## Application for Removal or Variation of a Condition following Grant of Planning Permission or Listed Building Consent

The development proposed is the erection of two four-bedroom dwellings (use class C3) adjacent to Indian Garden 2 restaurant (use class E) utilising existing access with associated parking and landscaping including reconfiguration of the restaurant's car park.

APP/V0510/W/22/3309056

Substitute revision 22.3337.100 P2 Proposed Site Plan with the amended 22.3337.100\_P3 - Proposed Site Plan and revision 22.3337.105 P2 Proposed Landscaping Plan with revision 22.3337.105\_P3 - Proposed Landscaping Plan, to highlight the surface finish to be retained as existing and the surface area to be covered with a loose shingle.

Drawing Title:
 Proposed Landscaping Plan

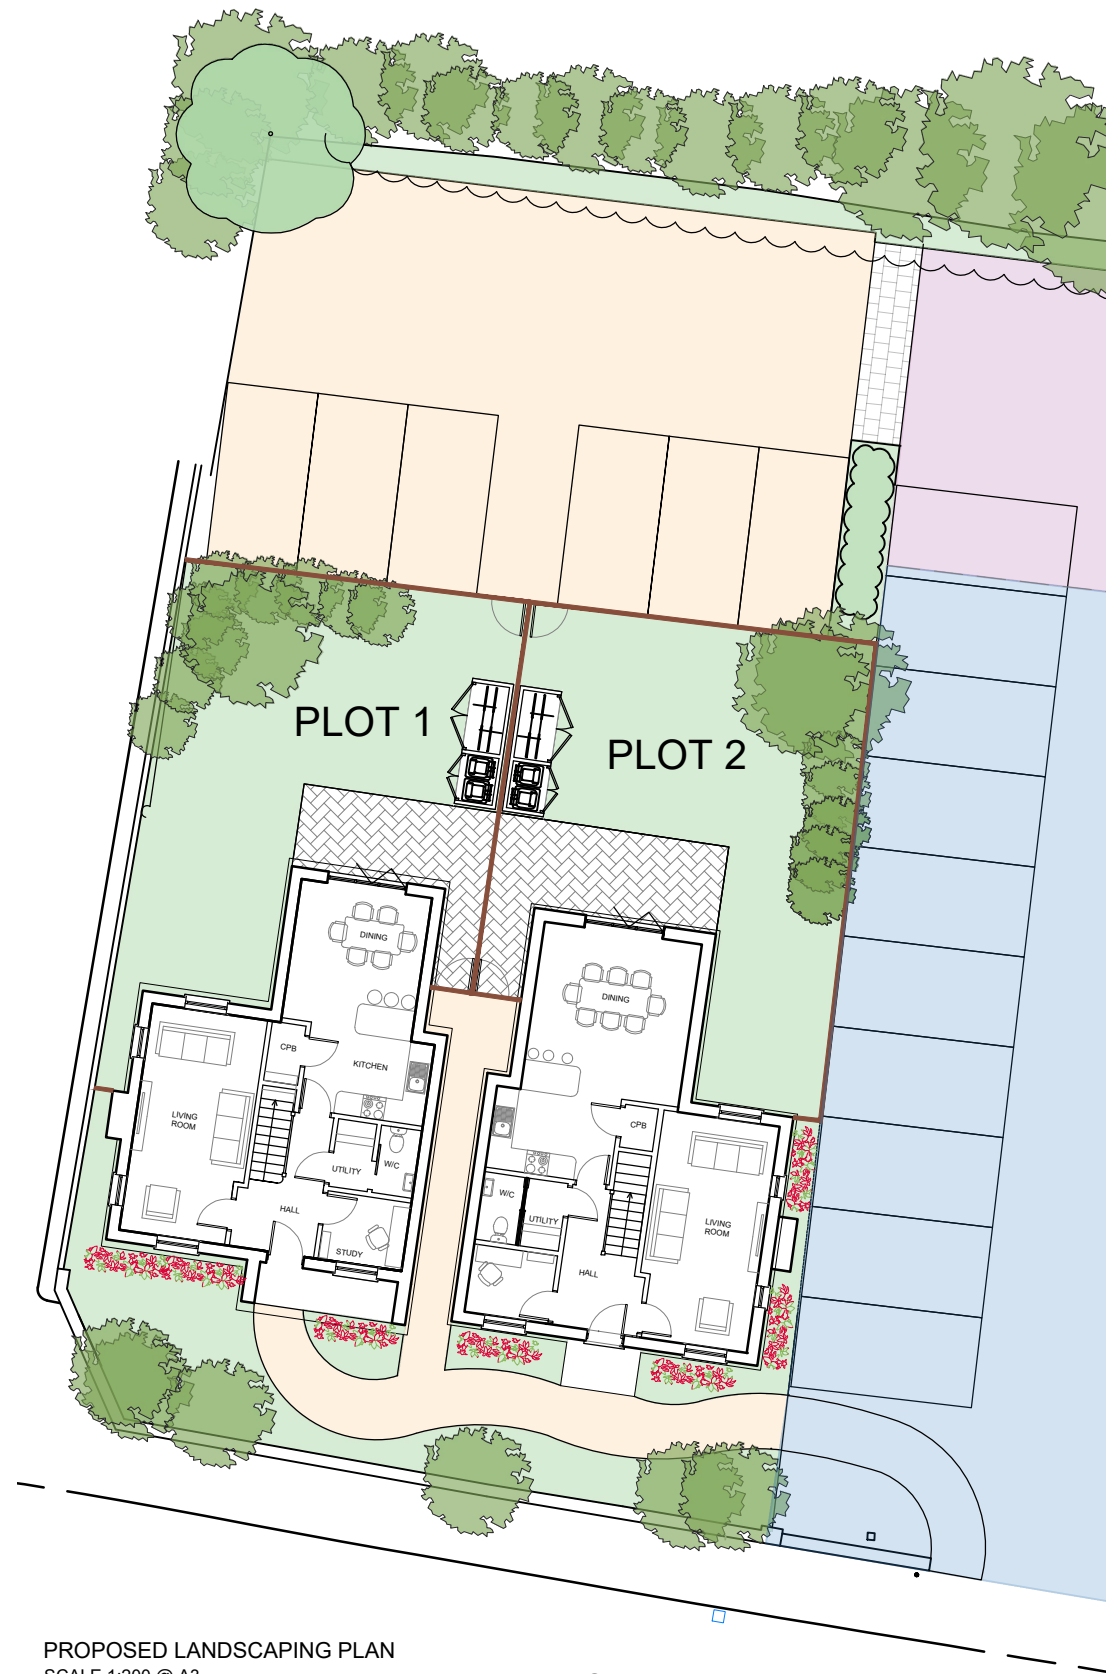
Amend the associated hard landscaping treatment to the existing car park.
